OXFORDSHIRE COUNTY COUNCIL'S RESPONSE TO CONSULTATION ON THE FOLLOWING DEVELOPMENT PROPOSAL

Application no: 14/01835/REM-2

Proposal: Reserved Matters to 05/01337/OUT - Details of the proposed village square including 44 public parking spaces and landscaped public open space

Transport

Title
**Planning Application 3:
 Village Square**

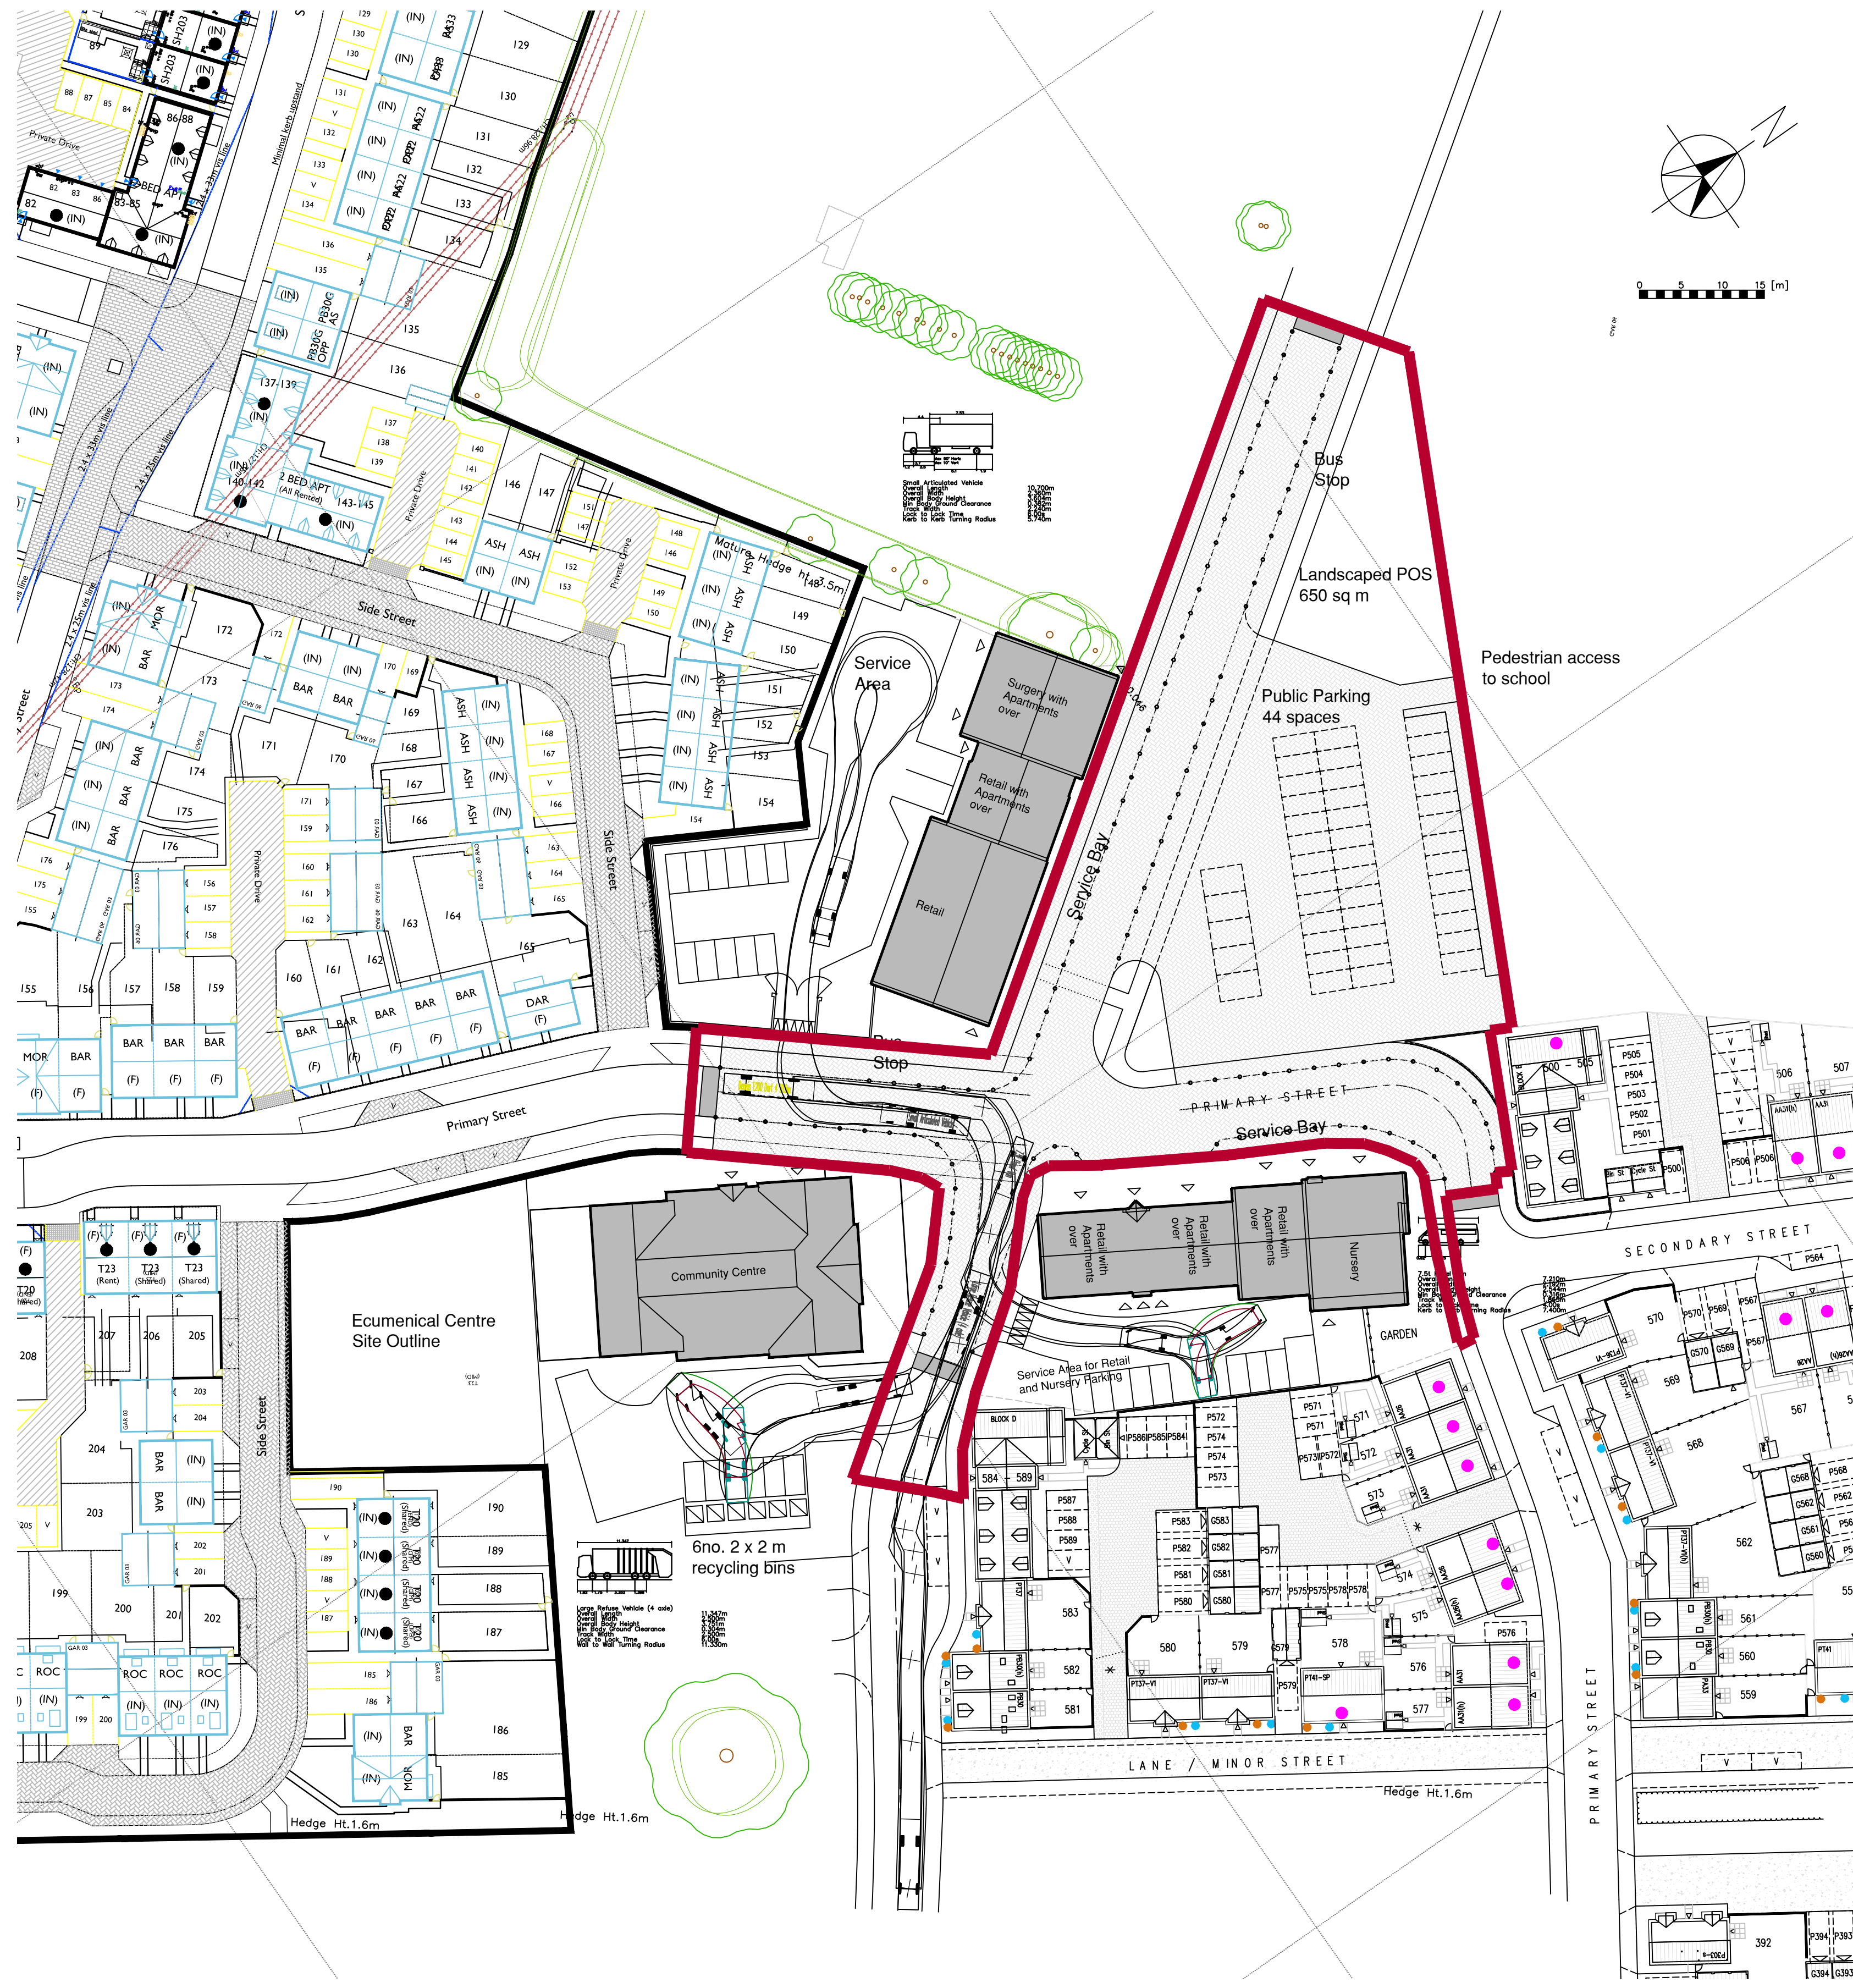
- 6m of manoeuvring space needs to be provided between rows of parking. Three spaces opposite the surgery have insufficient space to reverse and would need to reverse onto the footway, affecting pedestrian safety.

- The car park would not allow complete circulation – in effect there would be cul-de-sac opposite the surgery. This is likely to lead to congestion as drivers would have to do a three point turn to exit. Removal of the three spaces opposite the surgery would allow a complete one-way circulation, which would be more efficient. It may be possible to replace the spaces at the other end of the car park, adding onto the ends of rows.

- However, all spaces must be 5m x 2.5m, and an appropriate number of 'parent and child' spaces should be provided due to the need for nursery drop off.

- The proposed car park has two entrance/exits, which would allow it to be used as a cut through, which would make it less safe for pedestrians. It would be better to close off the southern access.

- No cycle parking is shown. While it is expected that secure cycle parking for staff and residents should be provided within the retail sites, all public cycle parking will need to be provided in the village square. 10 sheffield stands (with appropriate spacing) should be provided – some could go at the end of the row of disabled parking spaces, some in the space freed up opposite the surgery by the removal of three parking spaces (see above) and some in the landscaped POS. Note – it is assumed that parking for the community hall and ecumenical centre can be provided within their curtilage.

- To ensure the safety of child pedestrians, the pedestrian access to the school should be through the POS not the car park. However, care is needed to ensure that the access and landscaping tie in with the school site plans (county council planning application R3.0094/15)

- The red line area includes parts of the spine road which was the subject of a separate reserved matters application. The outline of the road I this application does not match up with the spine road plans, in particular there are missing bus and service laybys.
